Recommendation Report for Planning Permission

REF NO: LU/355/13/

LOCATION: Chauffeur Taxis Ltd
135A Wick Street
Wick Littlehampton

PROPOSAL: Build additional storey to create a two bedroom flat, on top existing single storey building. Thereby creating additional dwelling on the site with access via external staircase to rear. Slight amendment to previously approved ground floor flat - Resubmission of LU/185/13

Drawing Title
Extension Scheme
Proposed Elevations

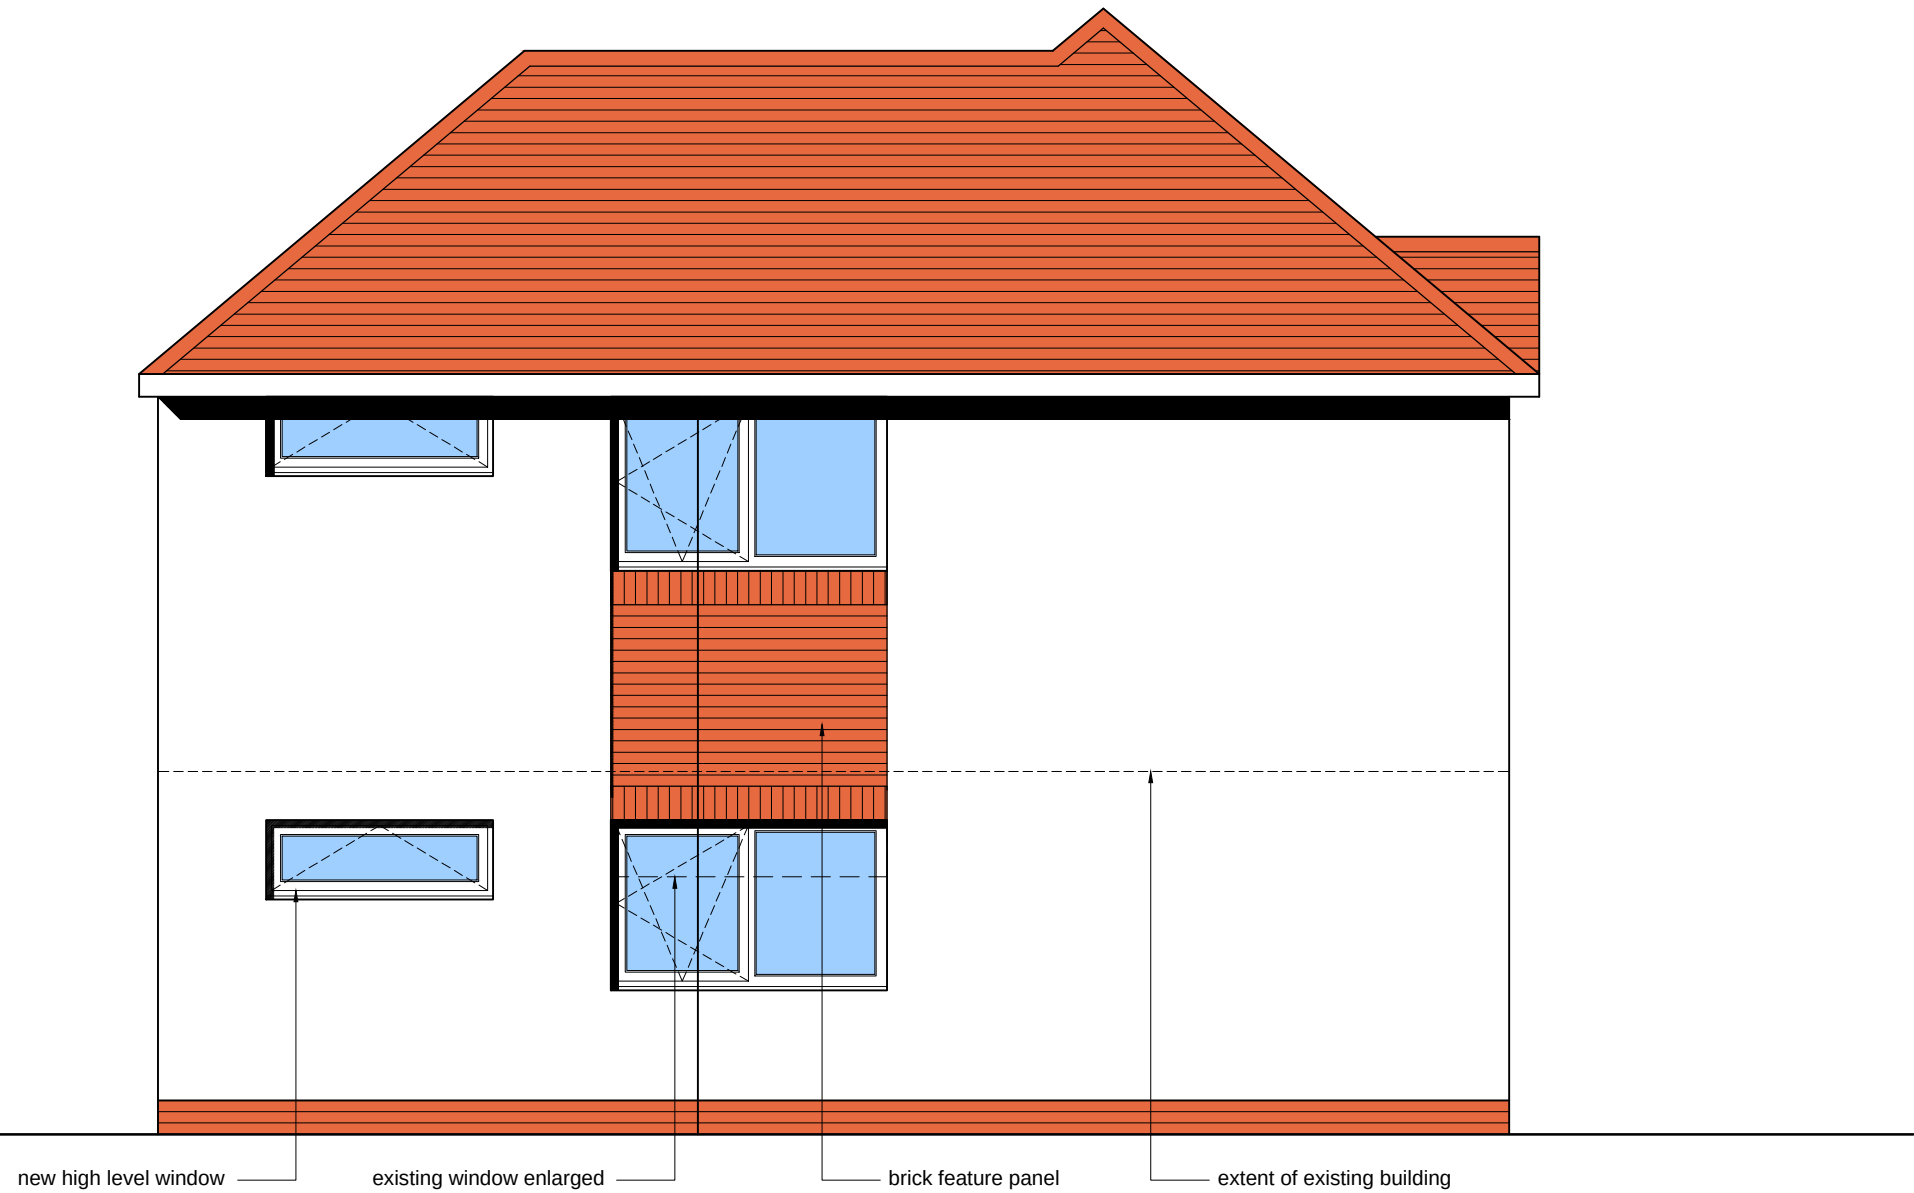
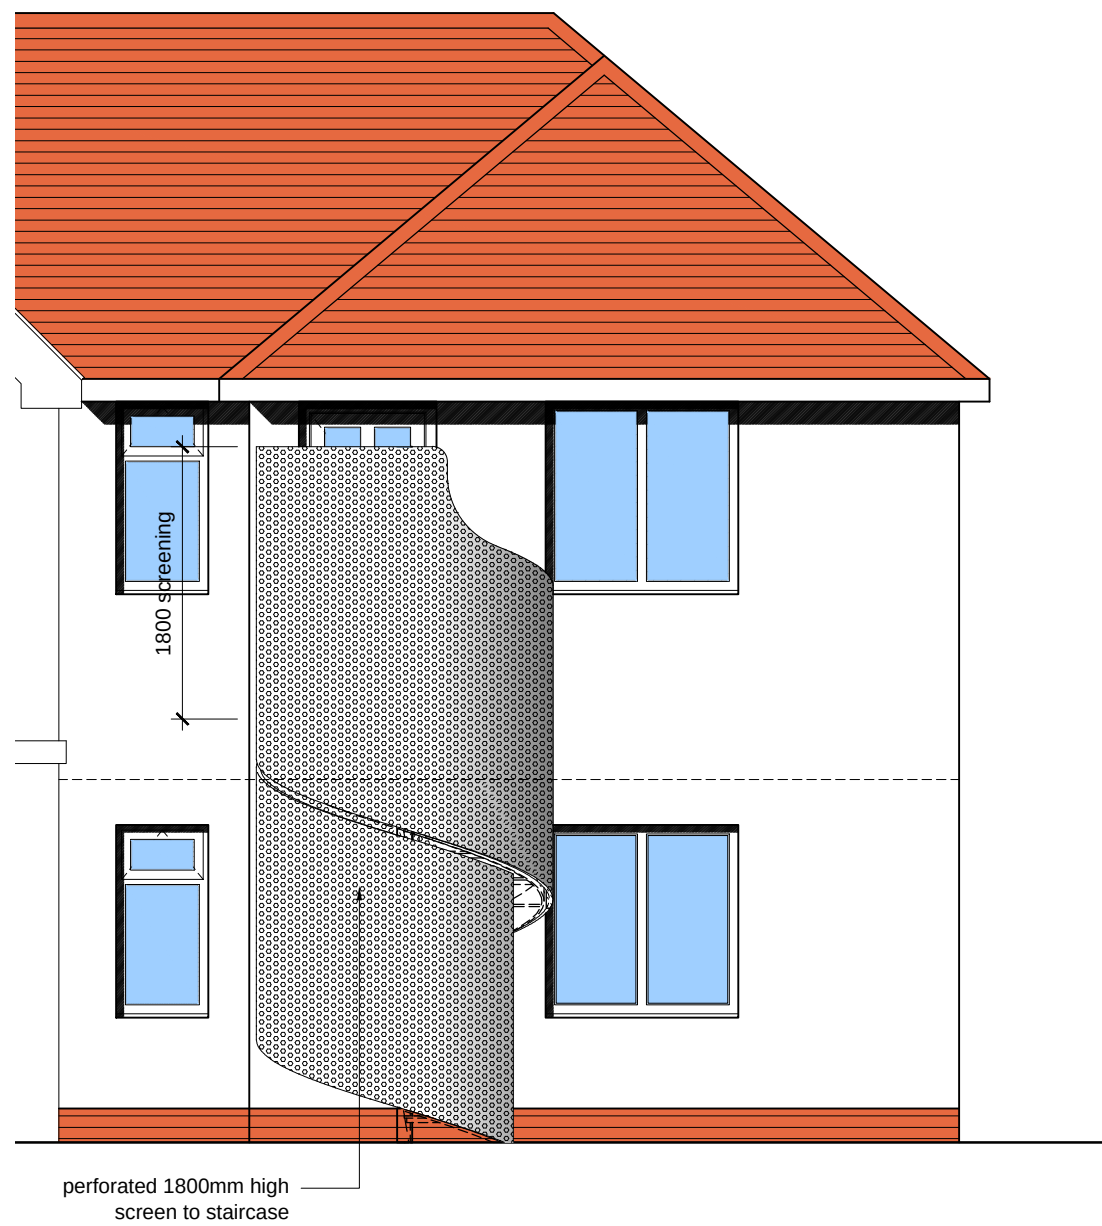
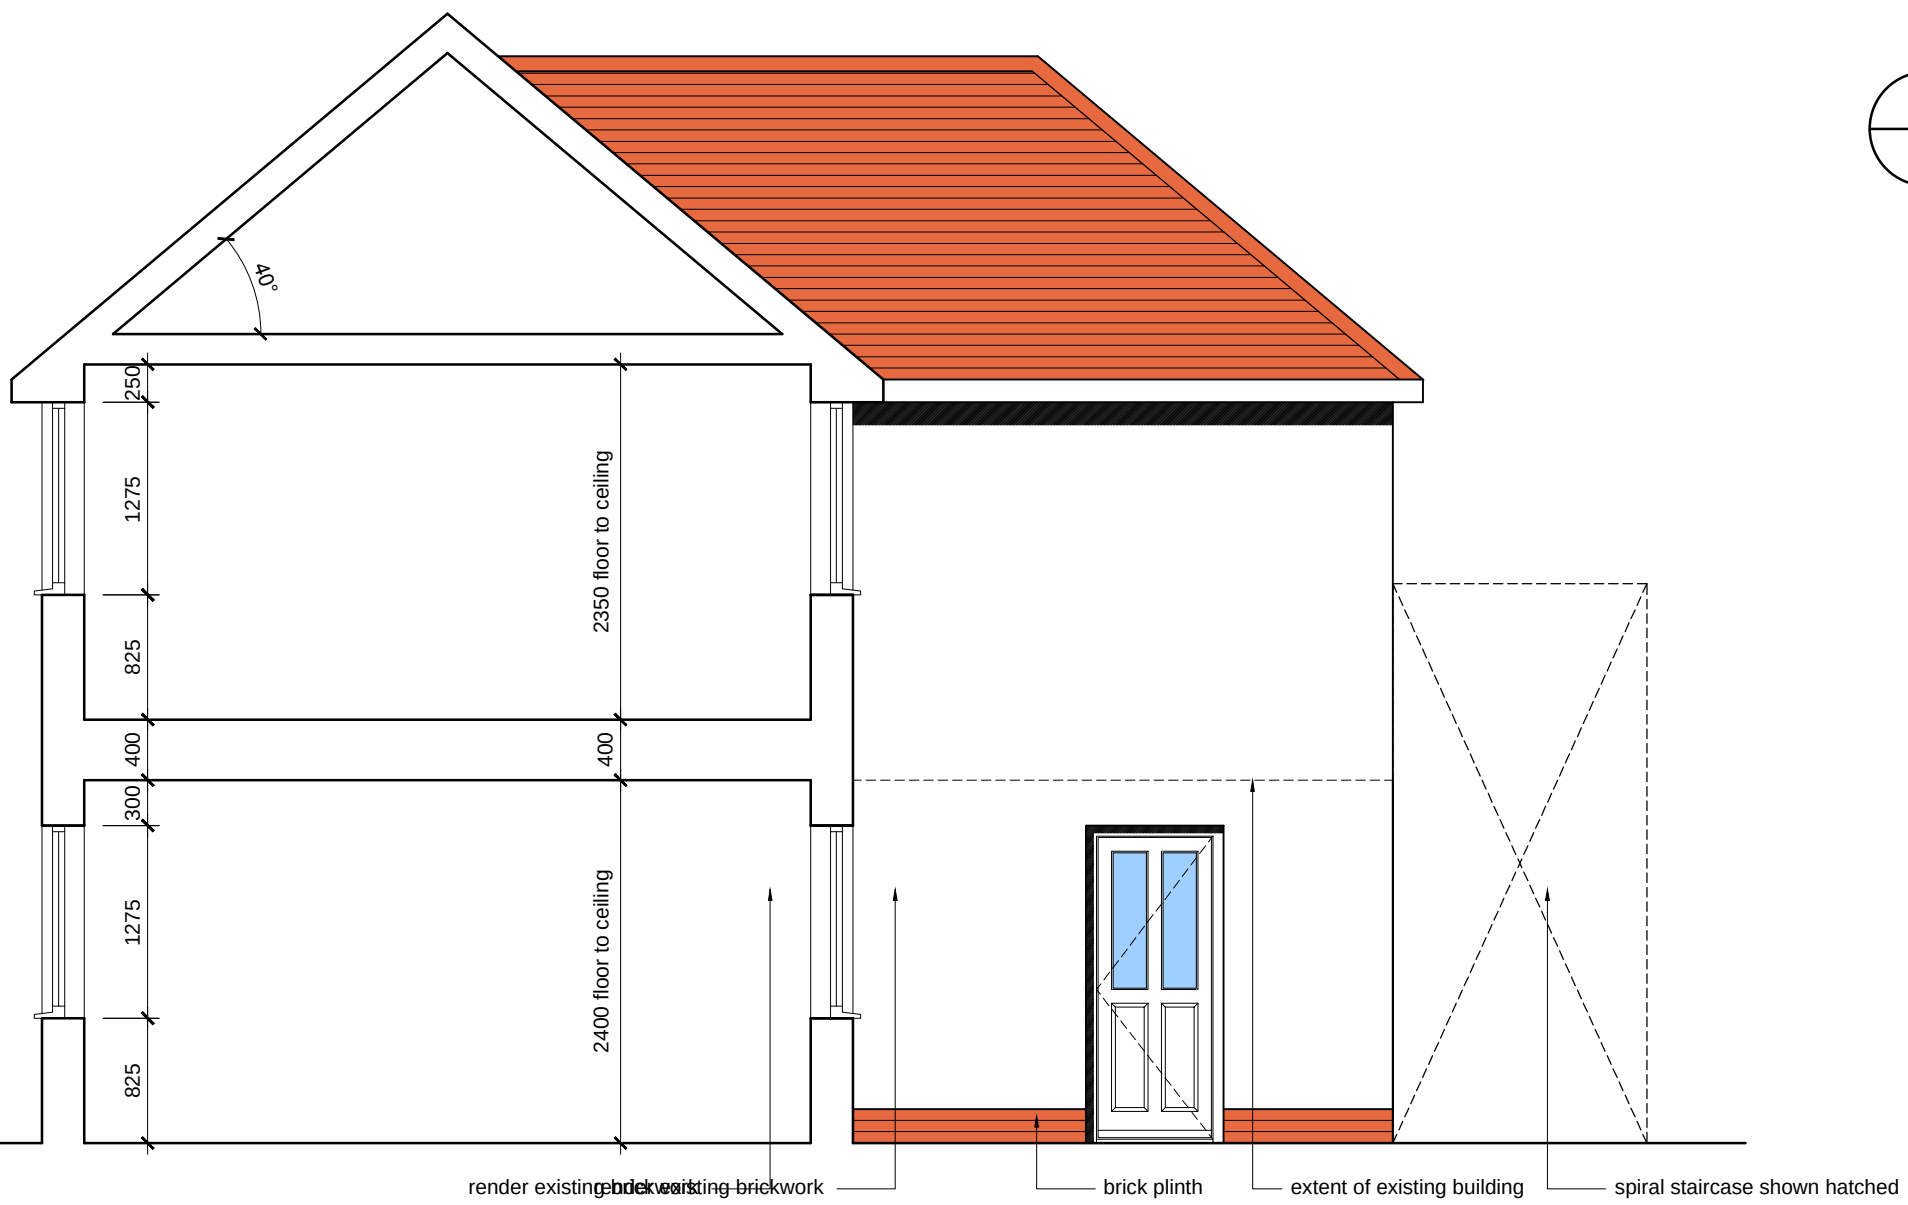
However, the proposed external spiral staircase on the rear (west) elevation is considered to be unacceptable in its design and use of materials. The staircase will be made from perforated steel in a wrap design which will be an alien and incongruous addition to the property. Even though it is situated to the rear, the nature of the corner plot and the necessary height of the external staircase at approximately 1.8m will mean that it is prominent in Courtwick Road. The external staircase will therefore have an unsympathetic appearance in relation to the property when viewed from this road. To screen the staircase in order to restrict overlooking is well intentioned but its design and steel construction would be in stark and harmful contrast with the rendered elevations of the property and those surrounding it.

Whilst the design and appearance of the extension is considered acceptable, it is the rear external staircase that will cause harm to the property. Due to the corner location of the property and necessary height of the external staircase to reach first floor level, it have an unacceptable adverse impact on the visual amenities of the area. With the scheme also failing to meet the Internal Space Standards of the Emerging Local Plan, the proposal is recommended to be refused for the following reasons.

- 1 The external staircase by virtue of its design, height and use of materials will be unsympathetic and incongruous to the property and causes harm to the visual amenities of the surrounding area in conflict with policy GEN7 of the Arun District Local Plan.
